29 August 2018

**Town and Country Planning Act 1990.
The Town and Country Planning (Development Management Procedure) (England) Order
2015**

RE: 6/2018/1516/COND – Submission of details pursuant to condition 1 (material samples), 4 (listed building details), 5 (roof survey) and 6 (listed fabric protection details) on planning permission 6/2017/2746/LB at Ramada Hatfield St Albans Road West Hatfield AL10 9RH.

04-Latern Plan Detail
1 : 10

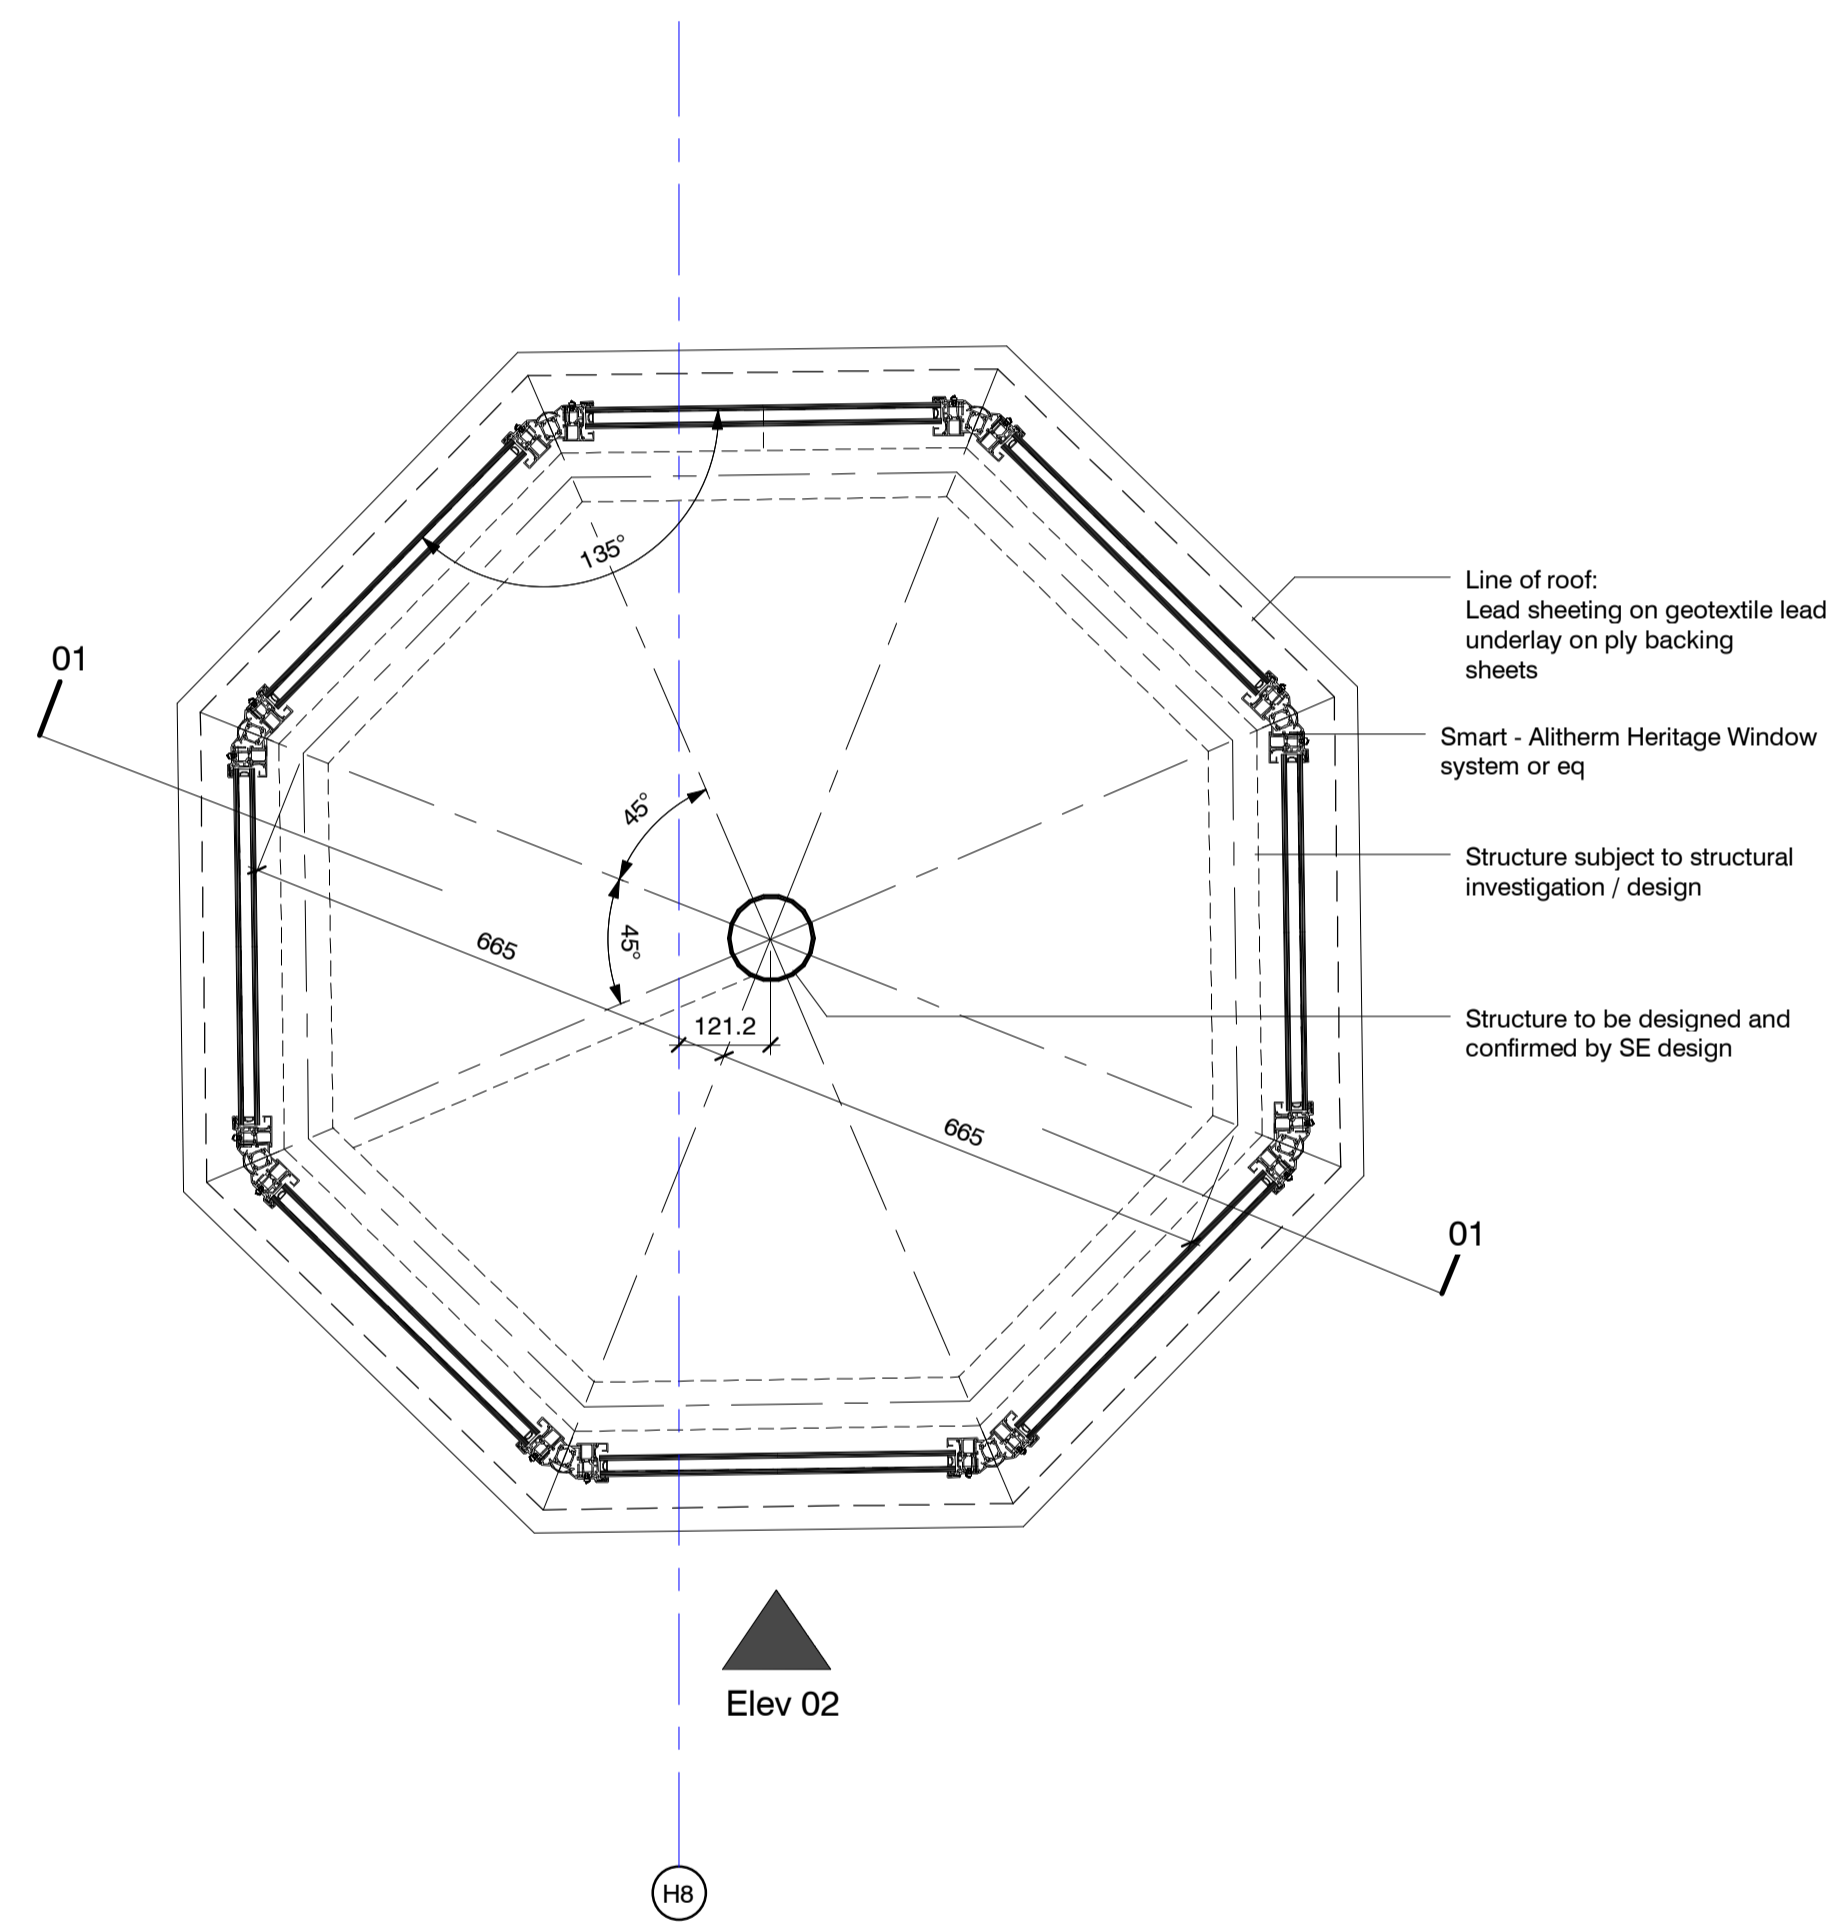
- (a) reinstatement of roof lantern (elevations at scale 1:20 and sections at 1:50);
- (b) retention of nibs to walls in the rear part of the listed building which were previously the chauffeur and garage quarters (floor plans at scale 1:50);

You will need to reapply for approval of samples and/or details for subsections (a), (d), (e) and (h) through to (k).

DRAWING TITLE
Demolition Listed Building Floor Plans

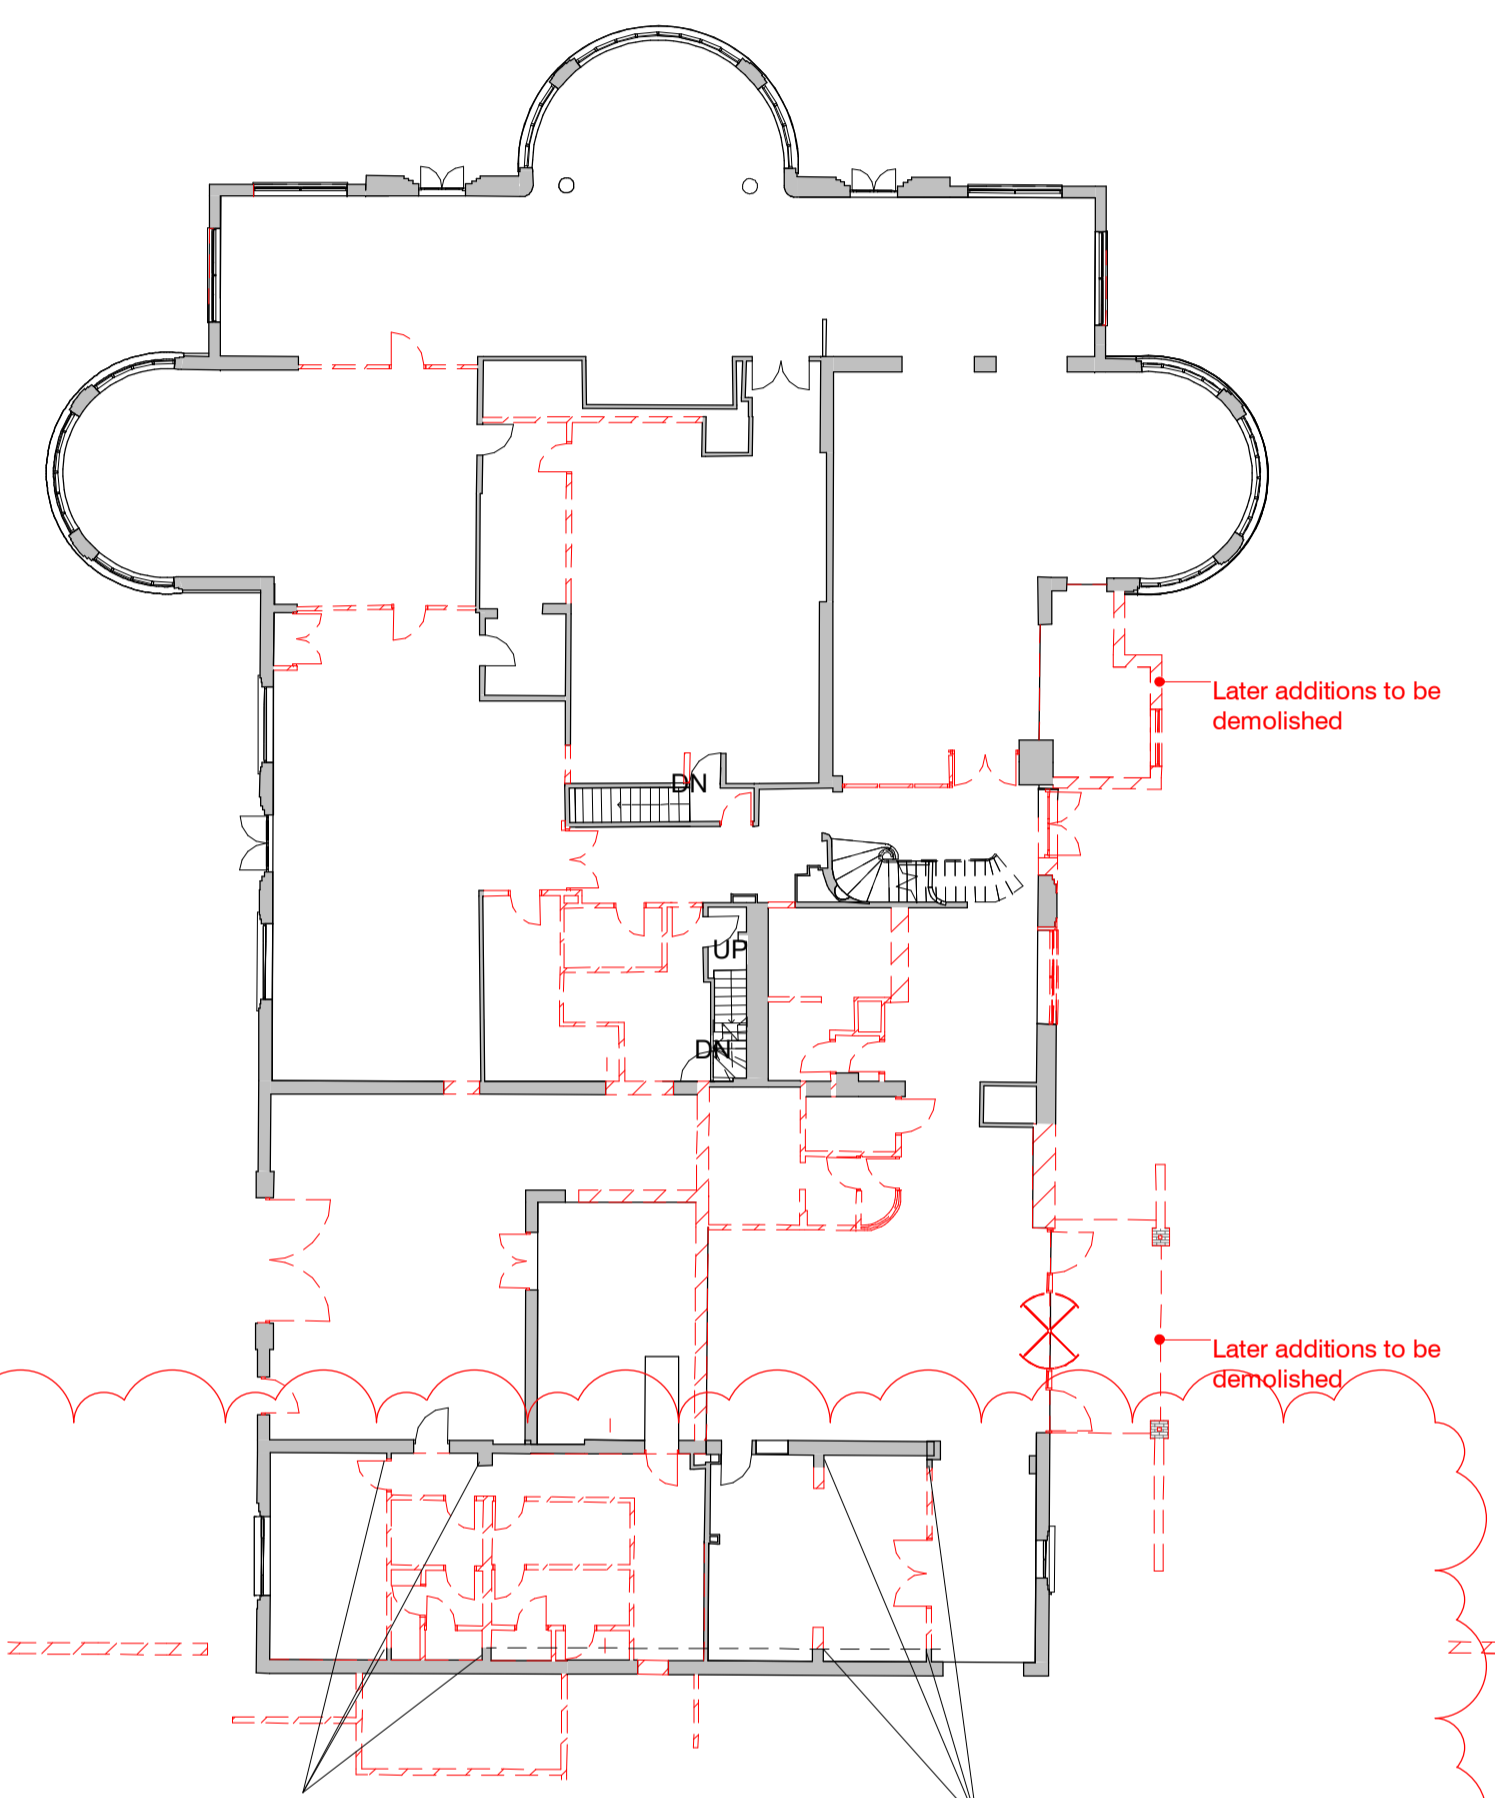
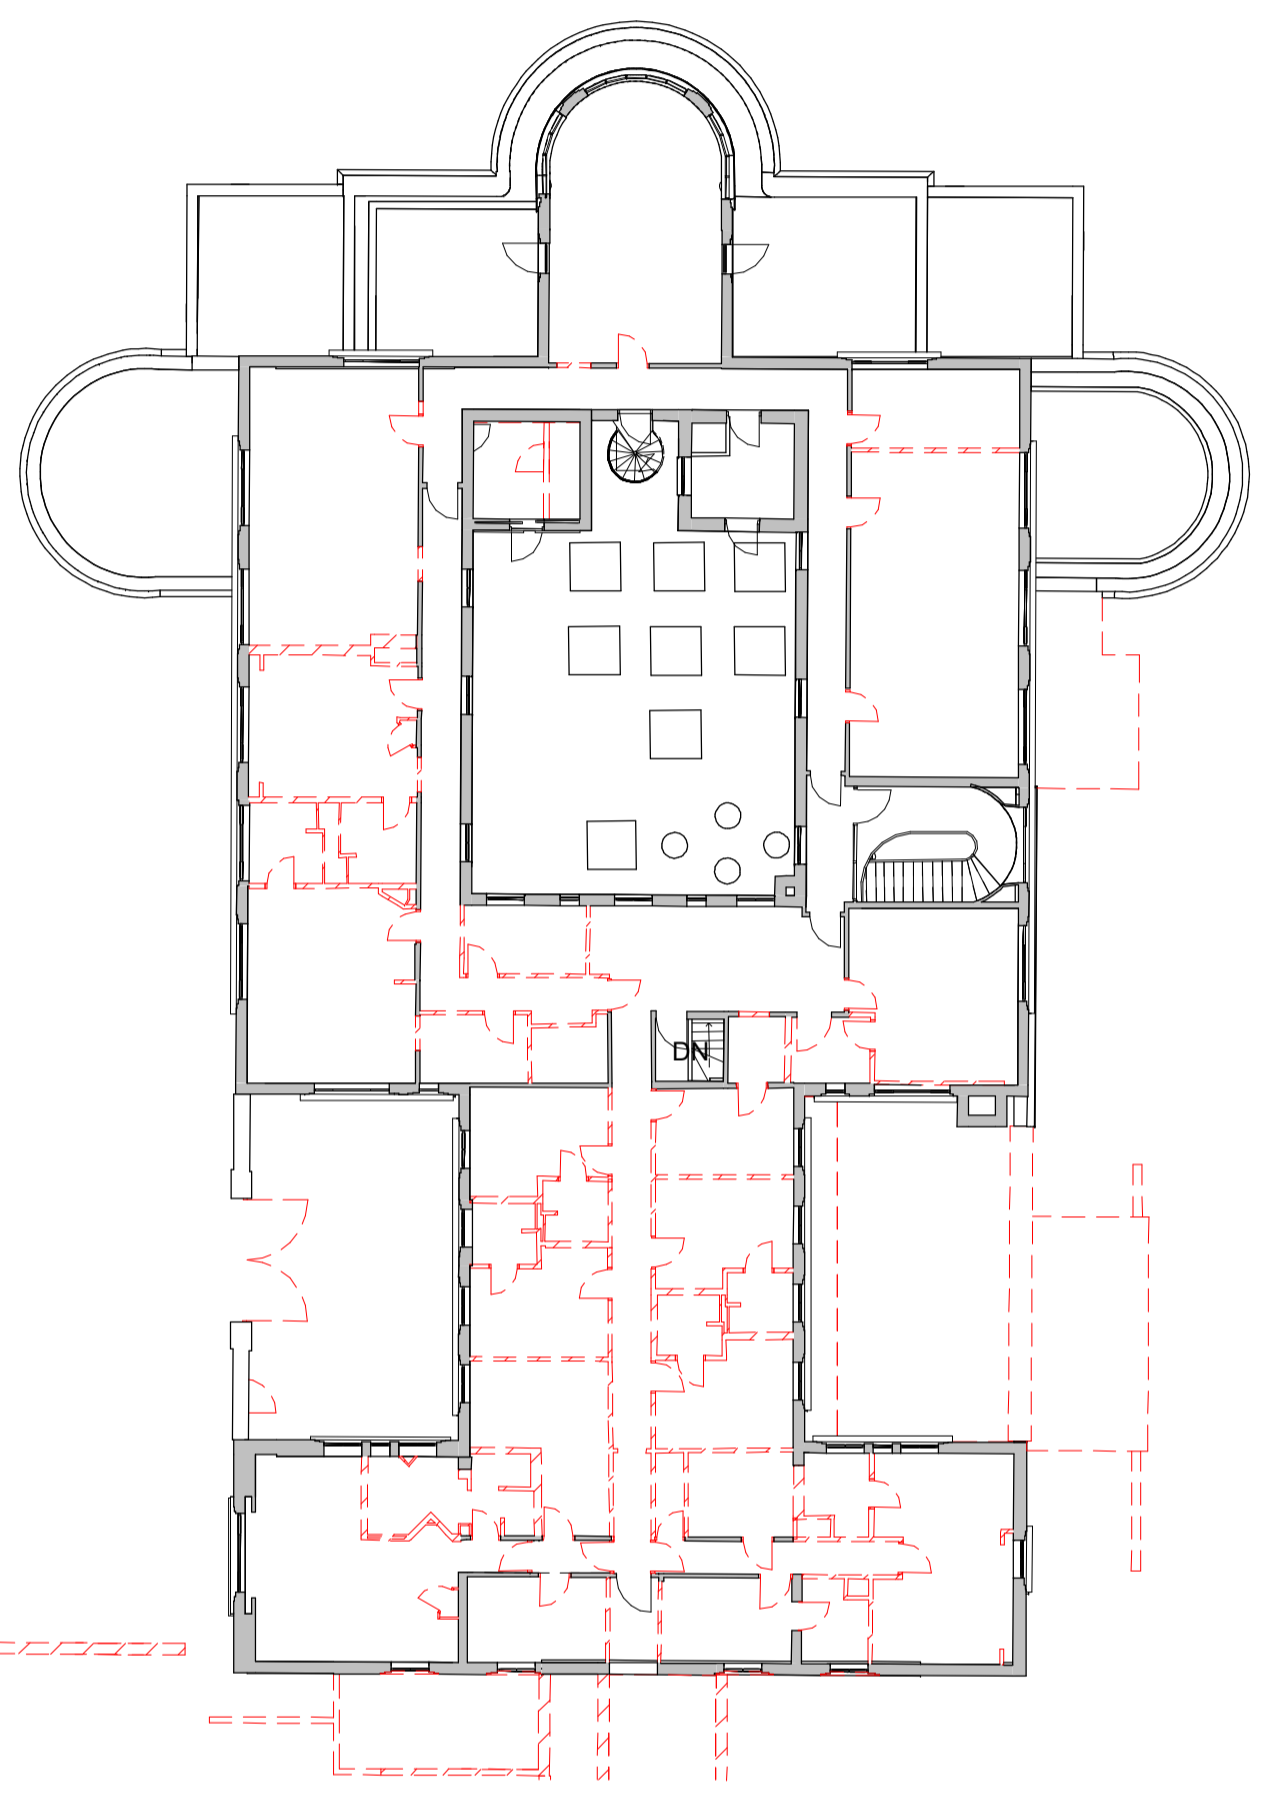
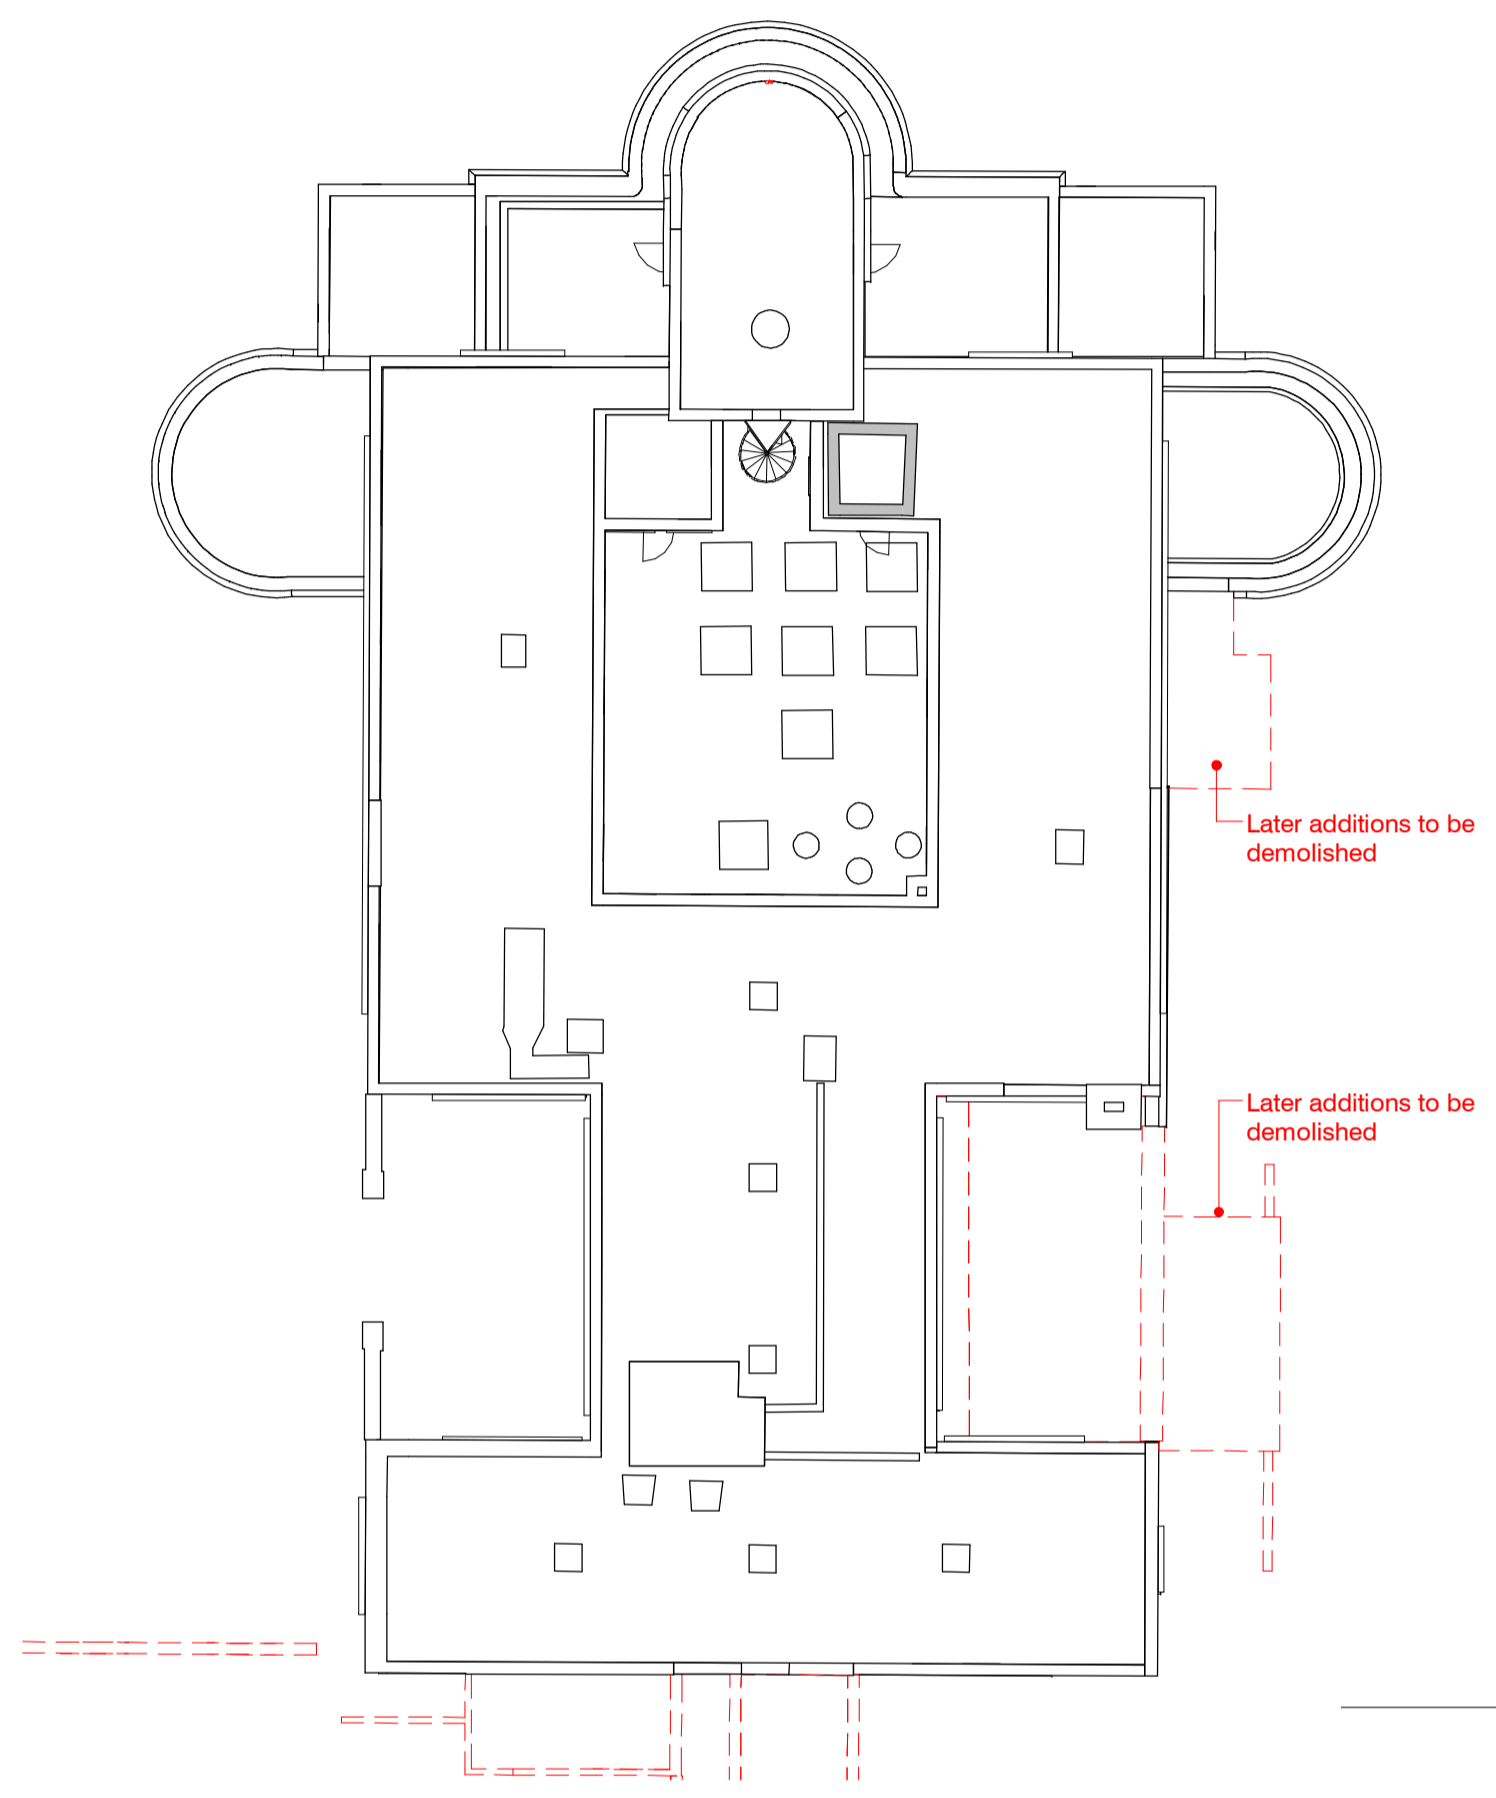
- (b) Drawings Nos COMET-STL-XX-ZZ-DR-A-ZZZZ-46000-C75 and COMET-STL-XX-ZZ-DR-A-ZZZ-46001-C67
- (c) Drawing No COMET-STL-XX-OO-DR-A-ZZZZ-42013-C73
- (g) Drawing No COMET-STL-XX-ZZ-DR-A-ZZZZ-63003-C103

Welwyn Hatfield Borough Council’s Heritage Advisor was consulted on the details. I confirm that the details submitted are sufficient and acceptable for subsections b), (c), (g) of condition 4. The development shall be carried out in accordance with these approved details. Please note this does not include approval of the mortar sample, which is subject to condition 8.
